Application no: **3/2023/0075**

Address: **Tan Yard Farm Ribchester Road Hothersall PR3 3YA**

Proposal: **Proposed extensions and remodelling (with associated building works) to the existing two barns, to create two detached dwellings (previously subject to approval 3/2021/0771) together with the erection of two proposed detached garages and external works and change of use of land to residential curtilage.**

The Local Highway Authority have viewed the plans and highway related documents and have the following comments to make:

2264-P04
STUDIO JOHN BRIDGE

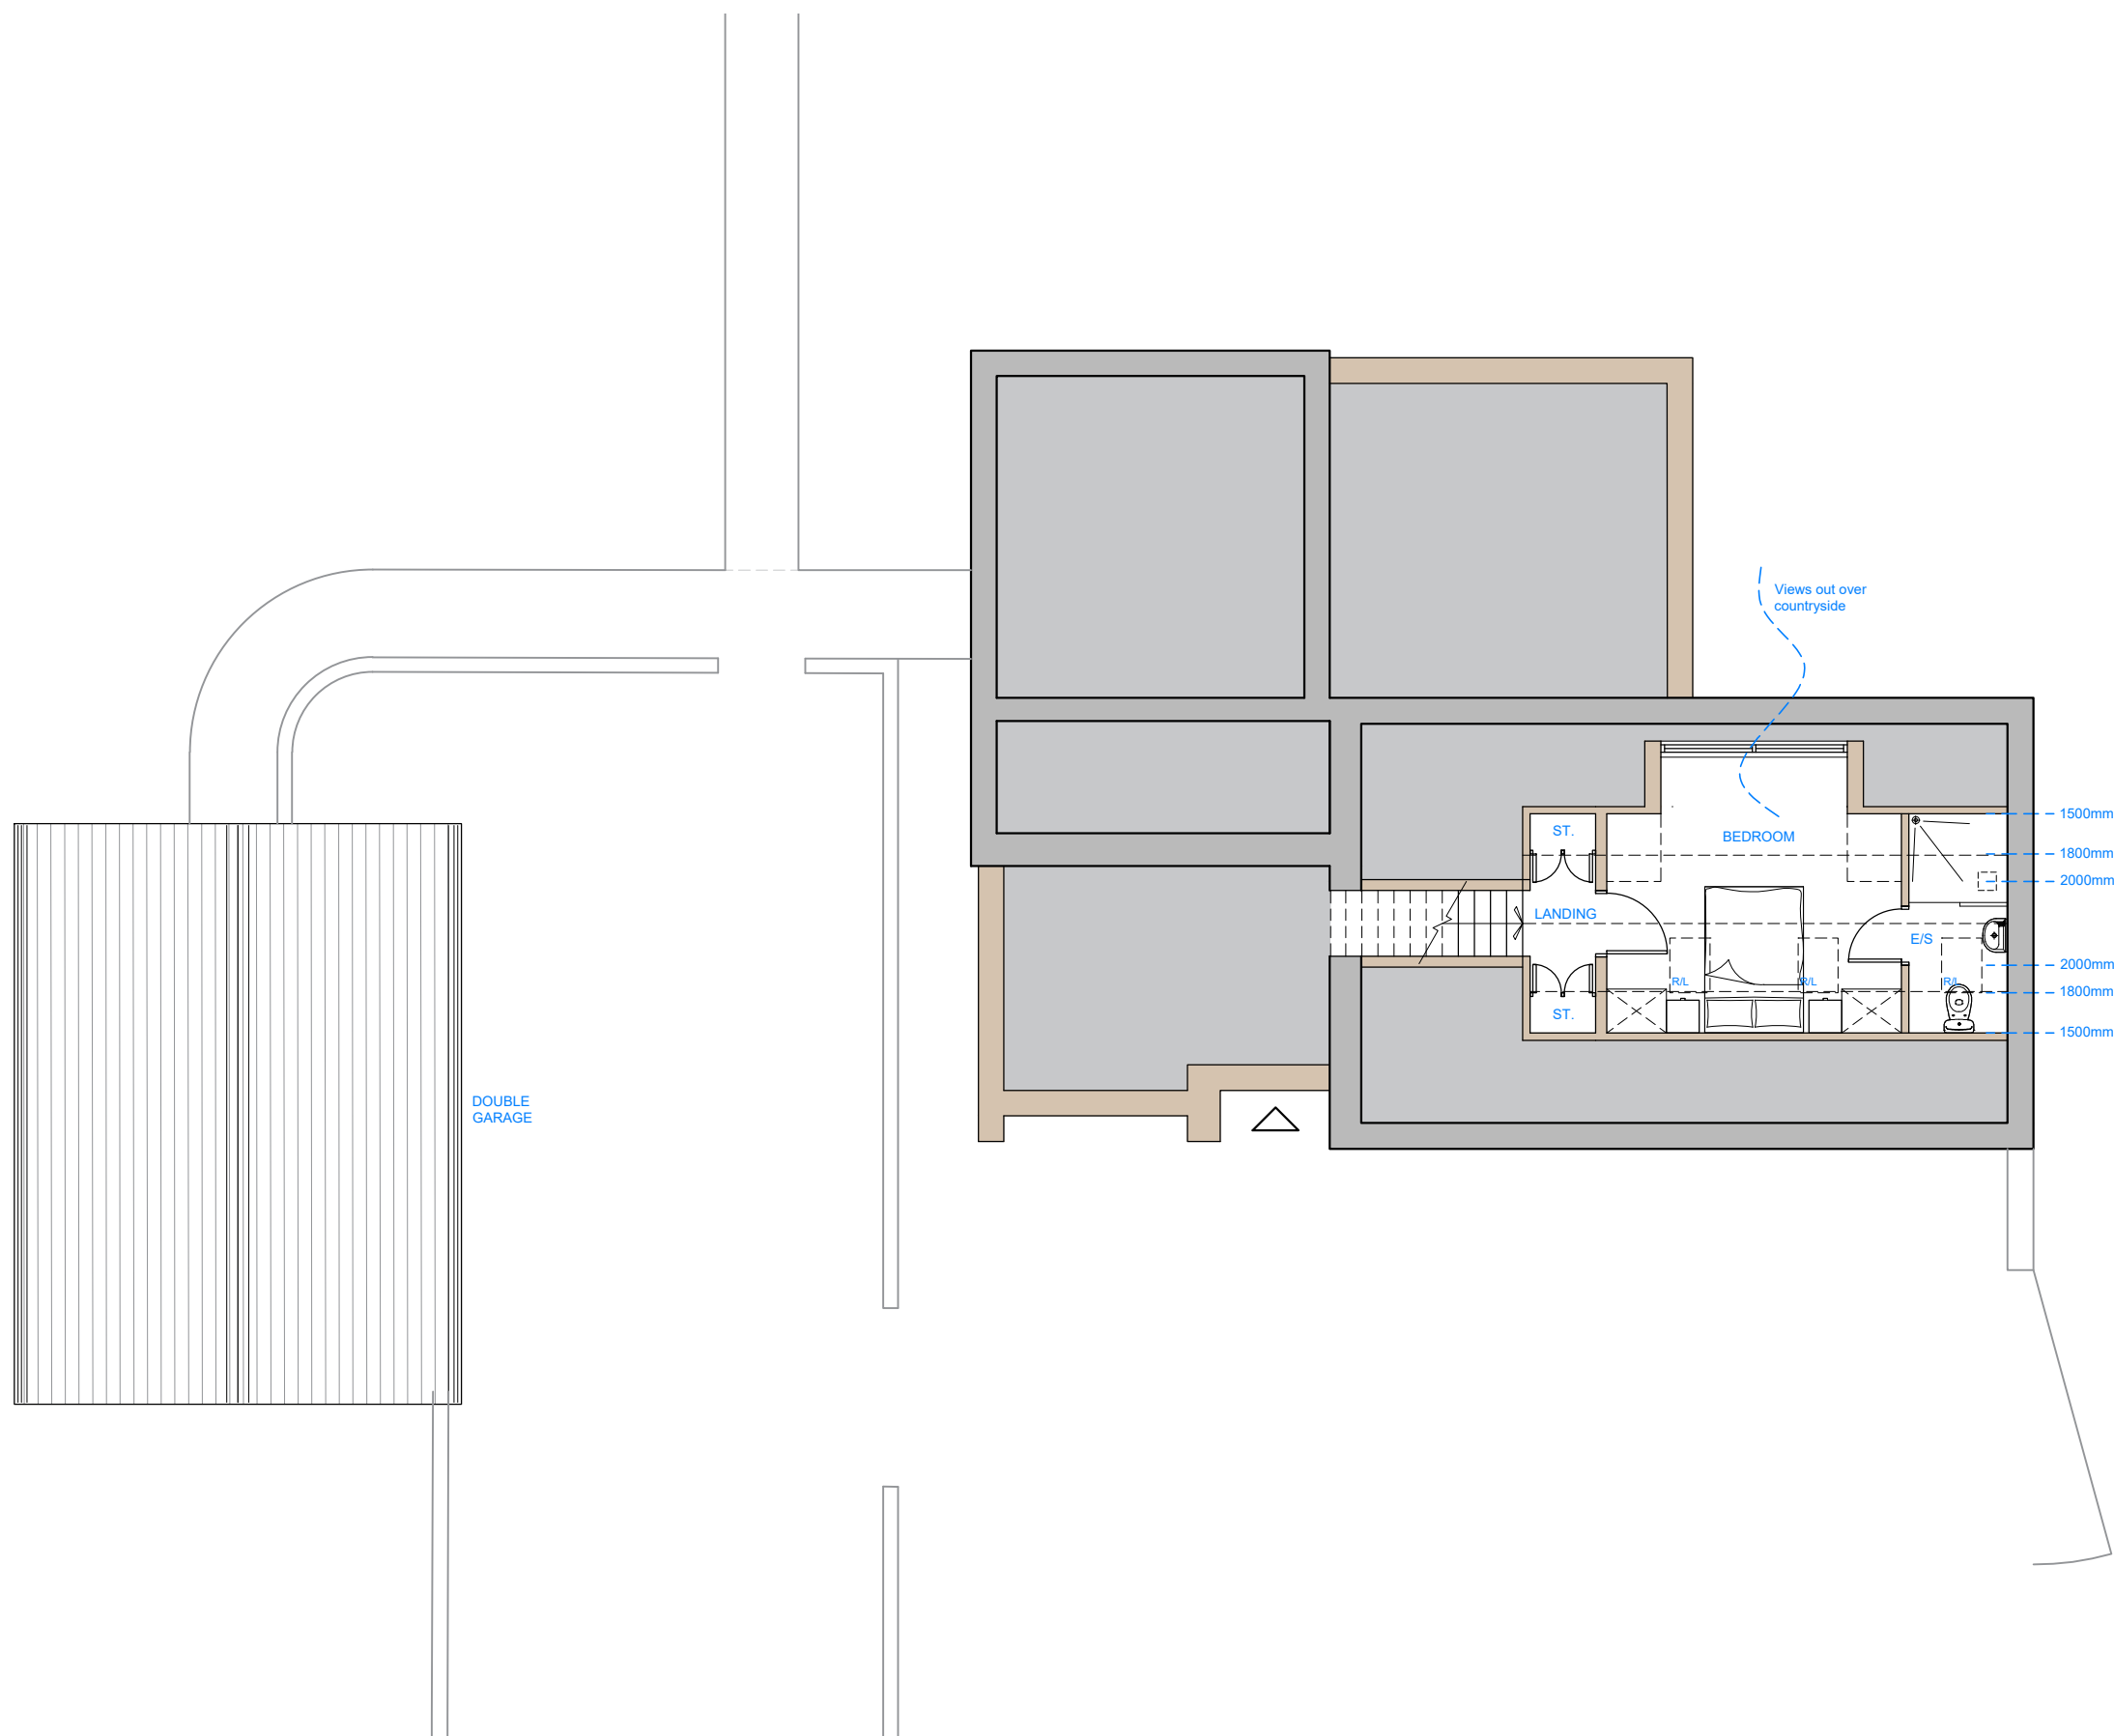
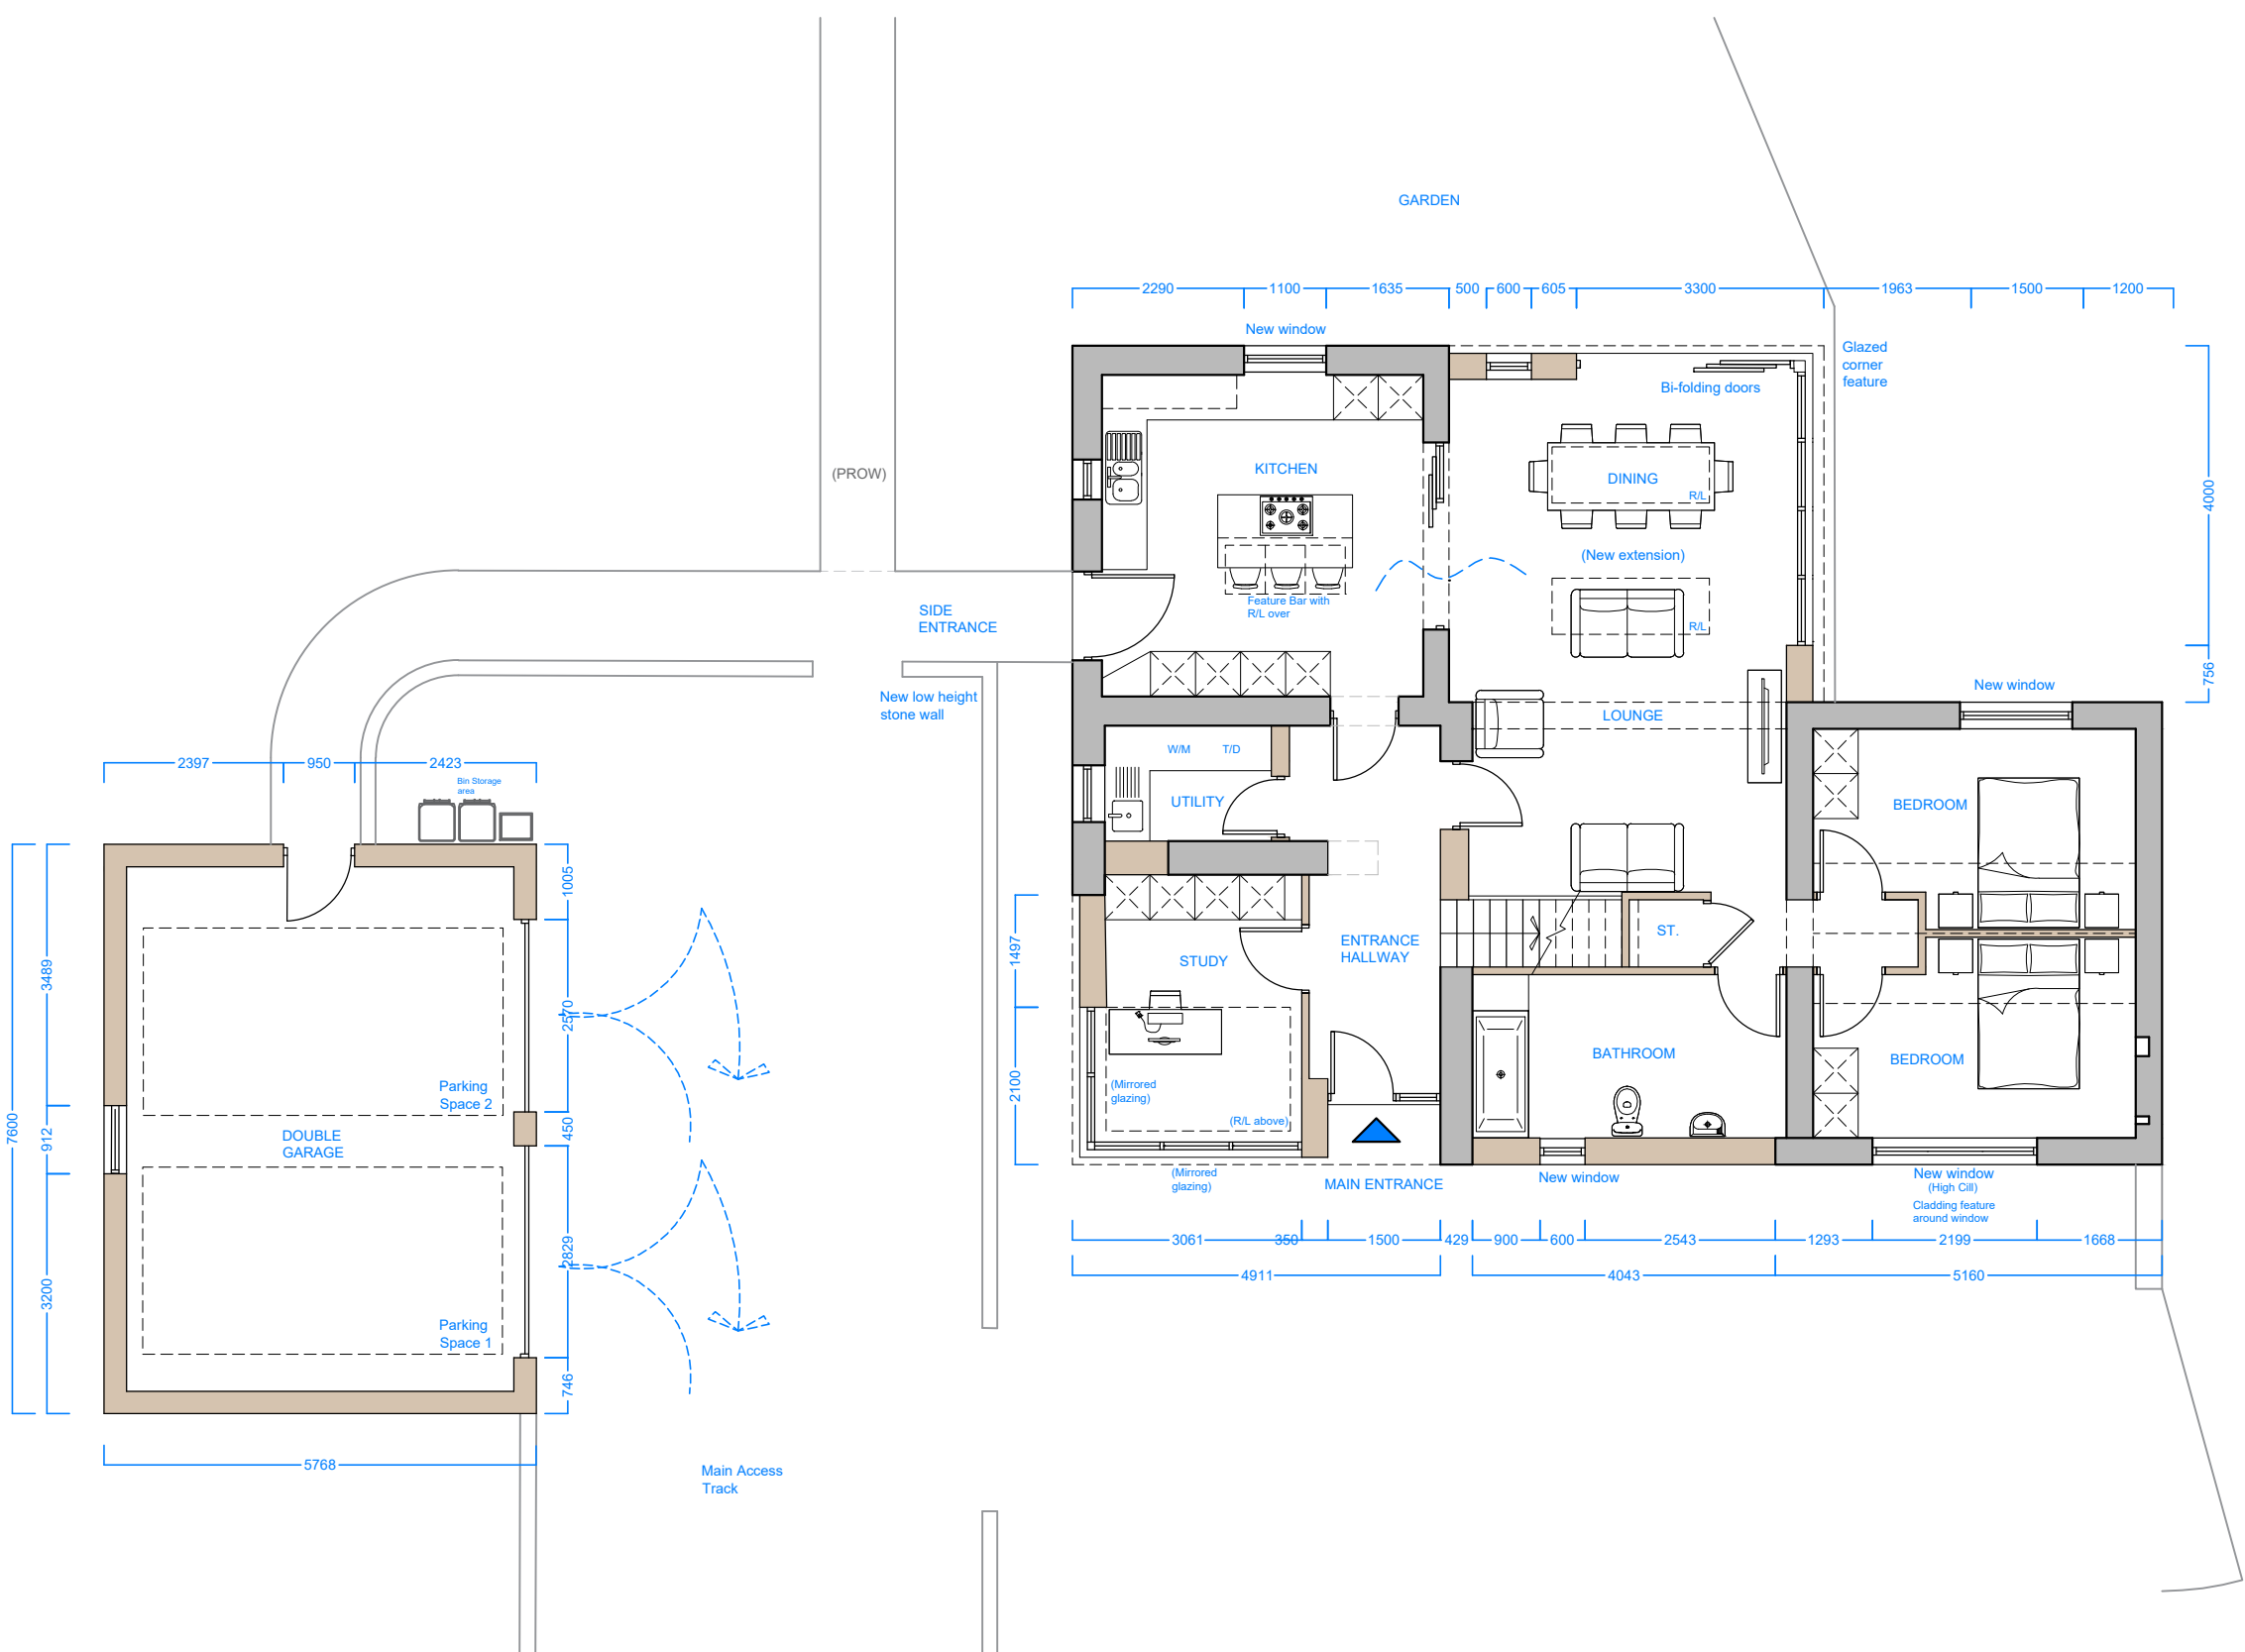
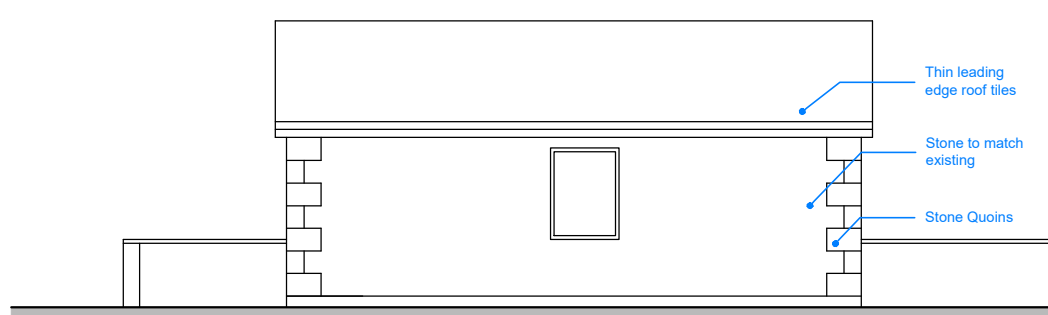
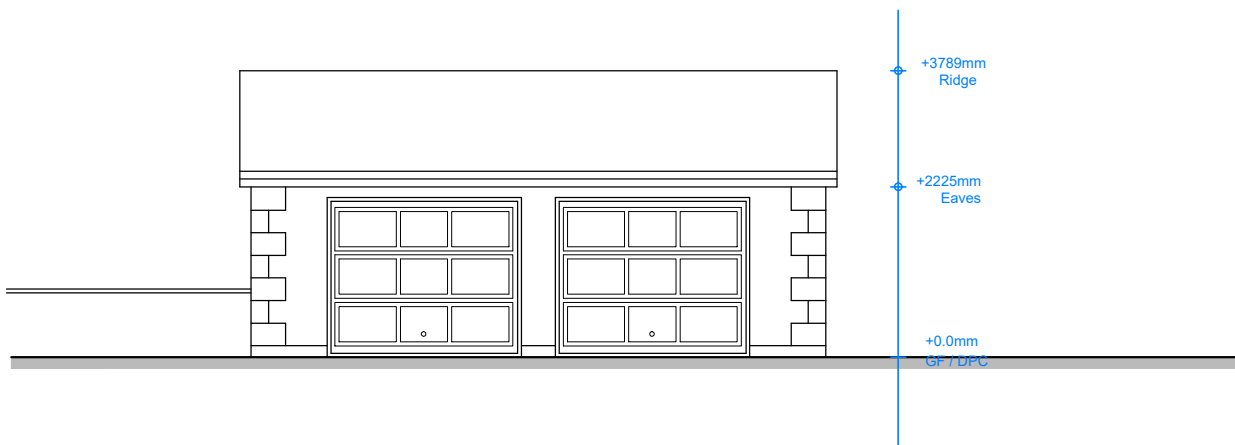
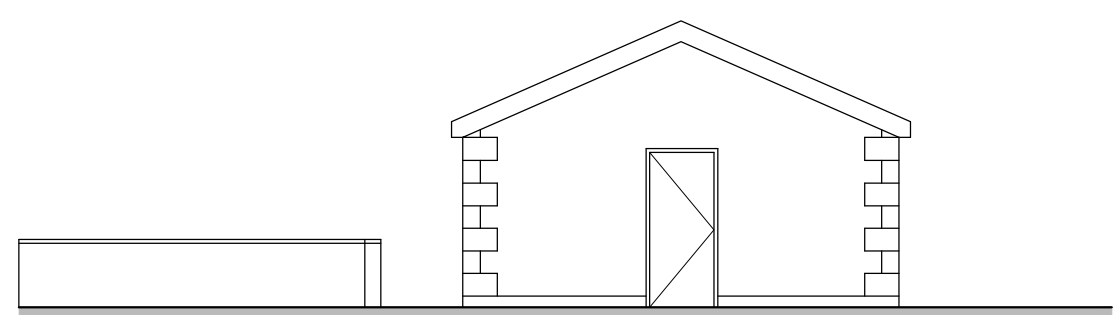
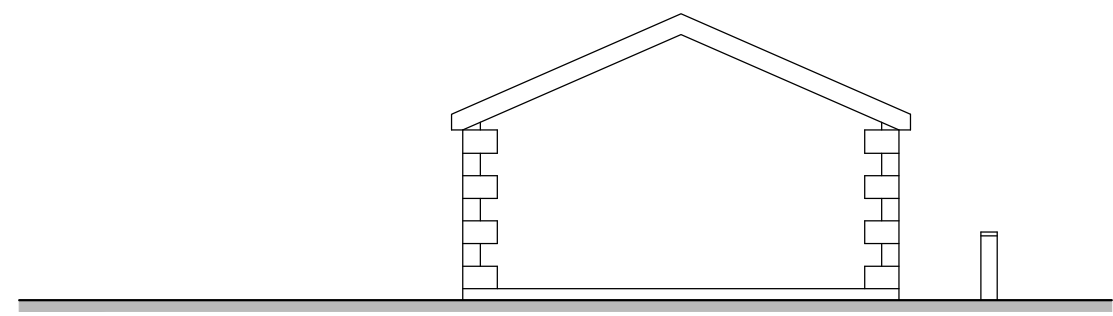
However, the LHA have reviewed Studio John Bridge drawing number 2264-P04 titled "Proposed Plans and Elevations- Dwelling 3" and are aware that the dimensions of the double garage will be 7.6m wide and 5.768m long. This does not comply with the LHAs guidance, which requires the internal dimensions of a double garage to be a minimum of 6m x 6m. Therefore, the LHA require the dimensions of the garage to be amended given that the proposed dwelling will not have access to a driveway and the access track will still provide access to Public Footpath FP0335027, which could be obstructed by parked

vehicles given that the double garage might be unusable in its current guise. Therefore, a revised plan is required.

The LHA have further reviewed Studio John Bridge drawing number 2264-P04 titled "Proposed Plans and Elevations- Dwelling 3" and require further information regarding the height of the stone wall located adjacent to Dwelling 3. The LHA require the stone wall, in this location, to be no higher than 1m to ensure that users of the Public Footpath are seen by vehicles using the proposed double garage.

The LHA also require the gap in the stone wall adjacent to Dwelling 3 and the path which connects to Public Footpath FP0323003 and leads to the adjoining field, to be a minimum of 2m wide. This should be shown on an amended plan.
